Conservation Area Advisory Committee

Meeting Date : 4 August 2014

BLOCK PLAN
AREA 90m x 90m
SCALE 1:500 on A4
CENTRE COORDINATES: 490821, 98291

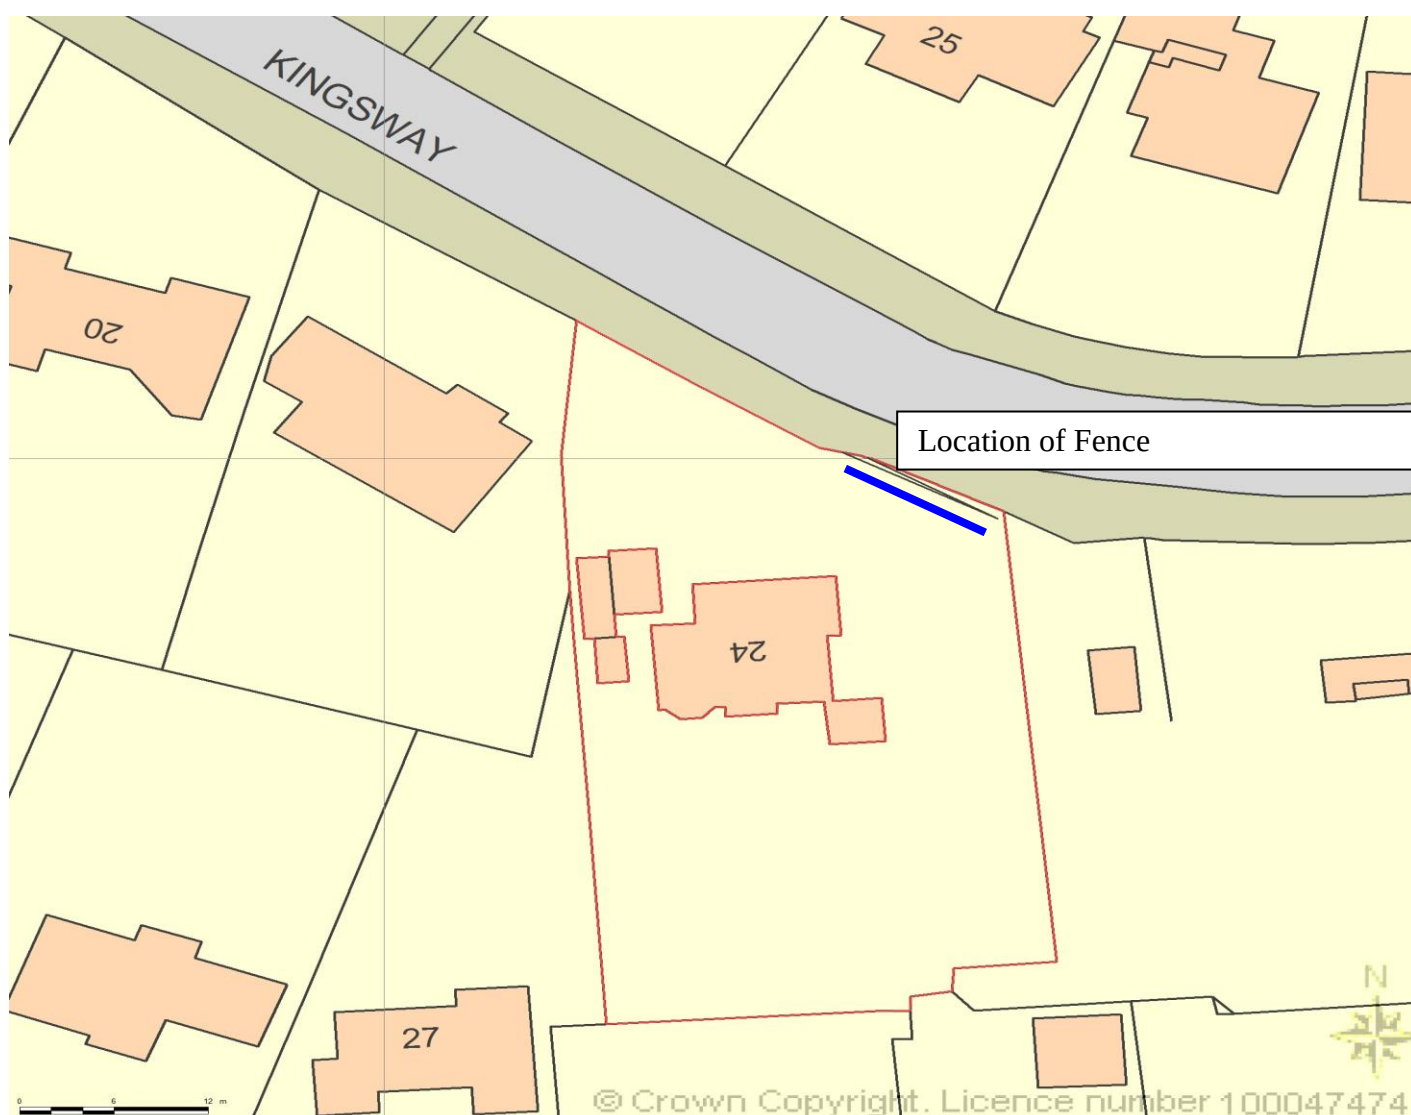
Ref	Description	Address	Design award
AW/184/14/HH	Retrospective application for the erection of a 6 panel, 1.5 m (h) x 1.5 m (w) fence at the north boundary of the property. This application affects the character and appearance of Craigwell House Conservation Area.	The White House 24 Kingsway Aldwick PO21 4DH	
Comments: Suggested Conditions: Objection Material unsuitable for location Suggest matching brick wall and/or bedding to restore "greening" in accordance with Conservation Statement.
